Planning Inspectorate Examination EN010137: Mona Offshore Wind

Cefn Meiriadog Community Council MNOW-ISP002

Deadline 5, 3 December 2024

Response of the Community Council to the Applicant's Change Request Application

Figure 1.6: Roadworks at a T-junction – traffic control by means of portable traffic signals.

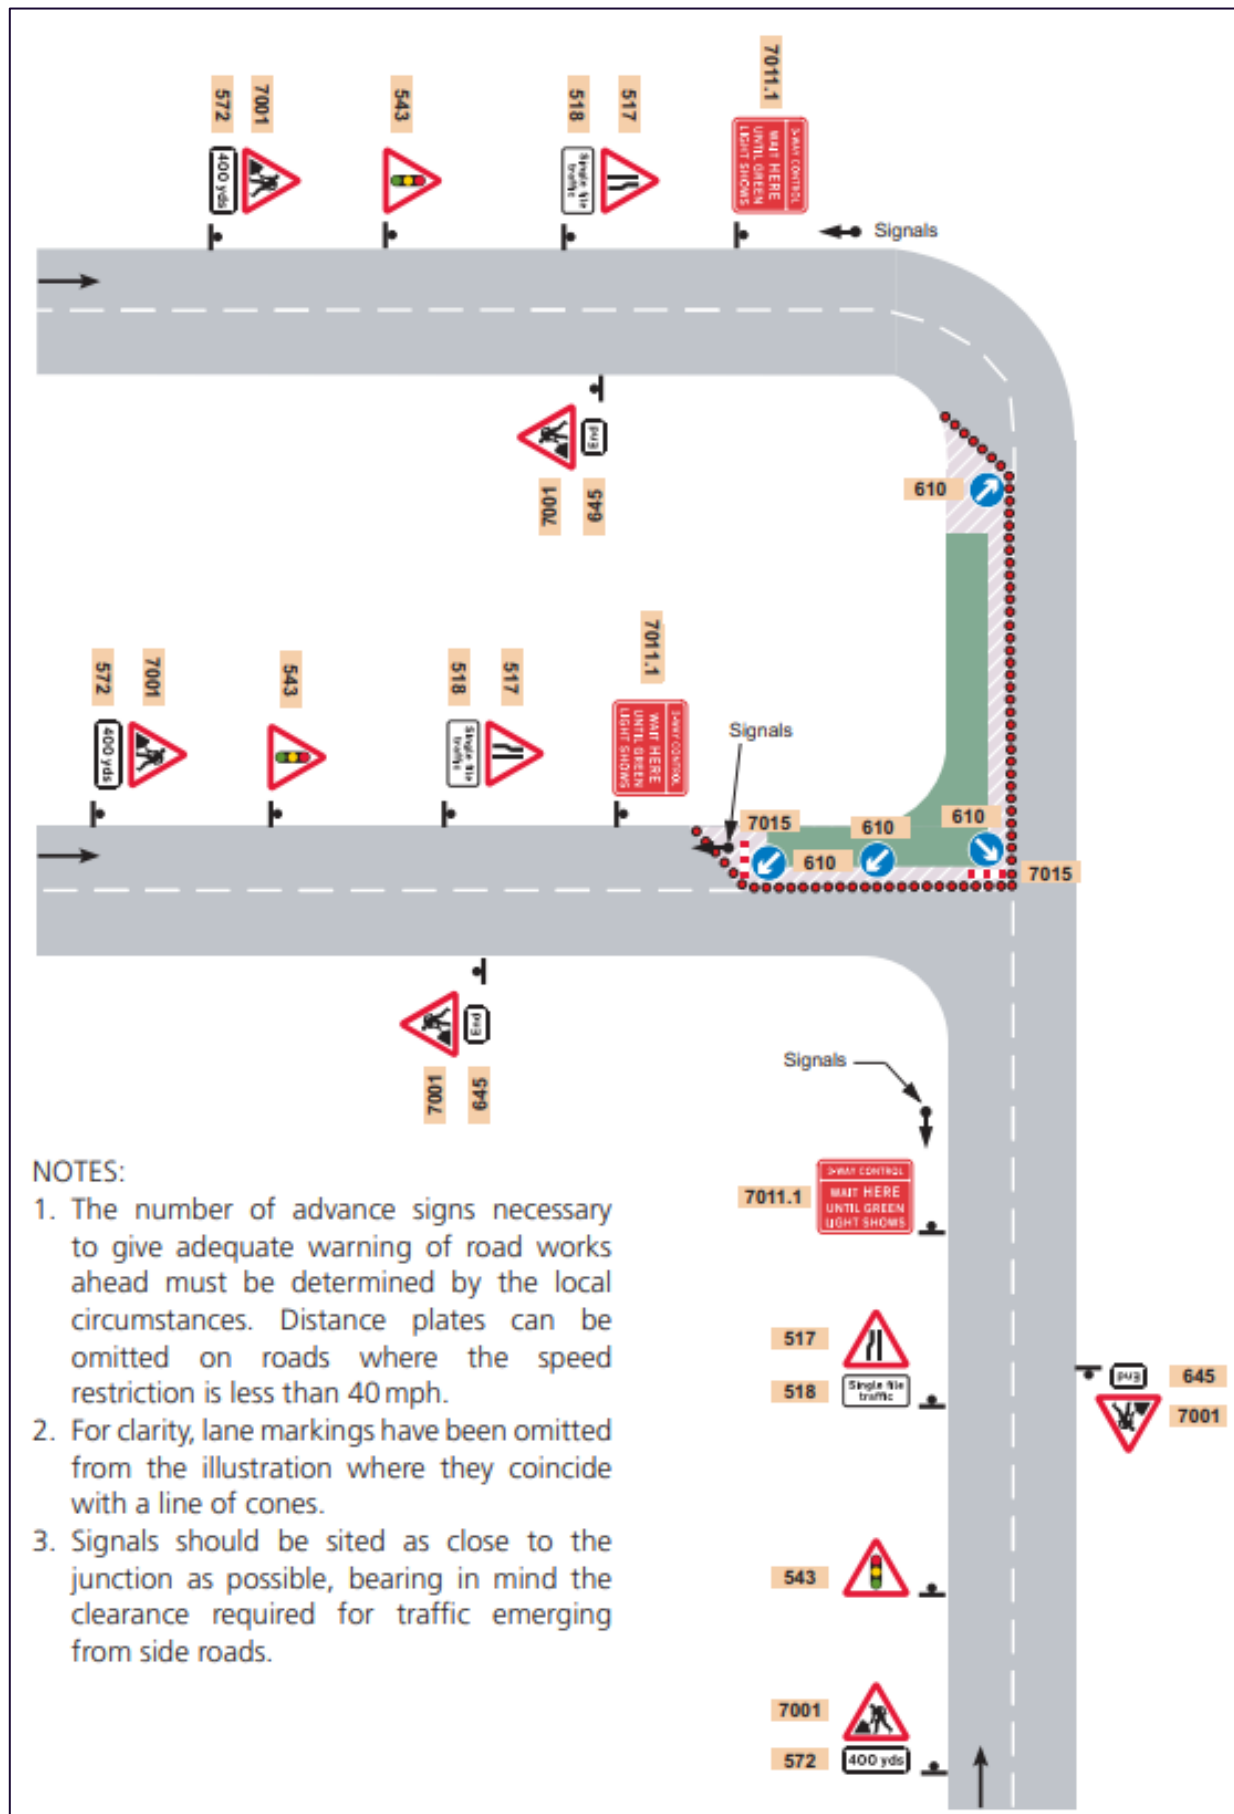
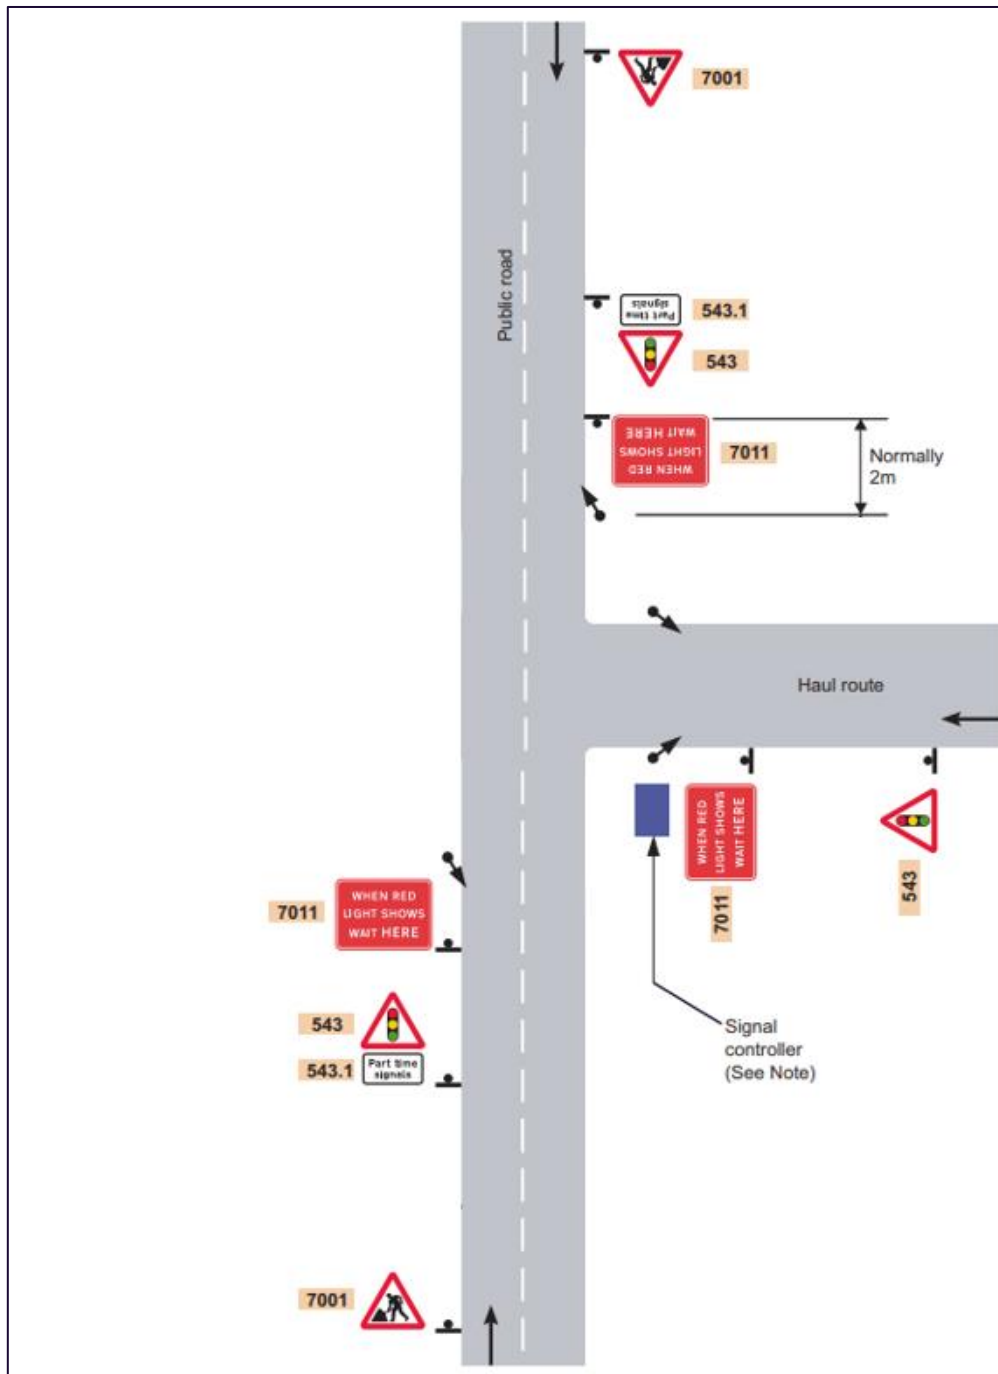
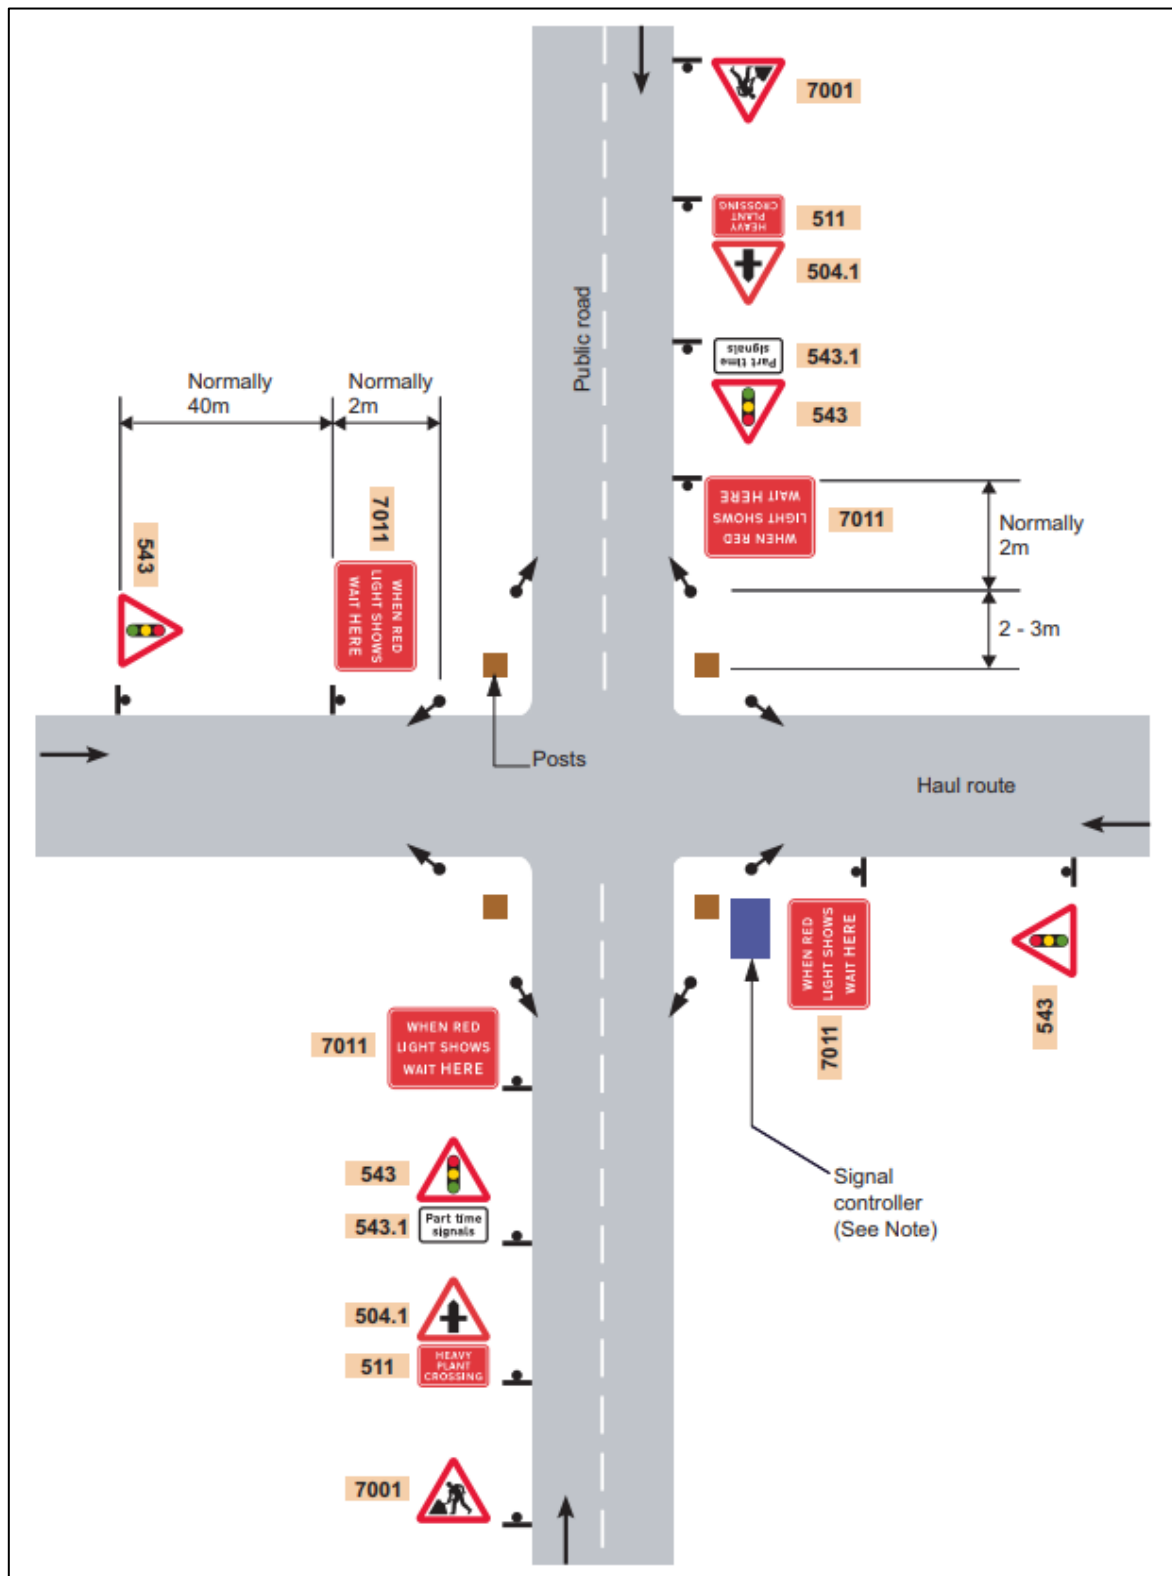
19. Purely in passing CMCC notes that in the OCTMP Figures 1.1 to 1.8, i.e. the depictions of road signage, all the road signs are monolingual. It is perfectly well understood that these are purely indicative examples and are, as the Applicant states, “generic in nature”. Nevertheless, similarly to the point made in paragraph 9 above, they display a regrettable lack of awareness of sensibilities within the community in which they are proposing to work for a long period and on which they will
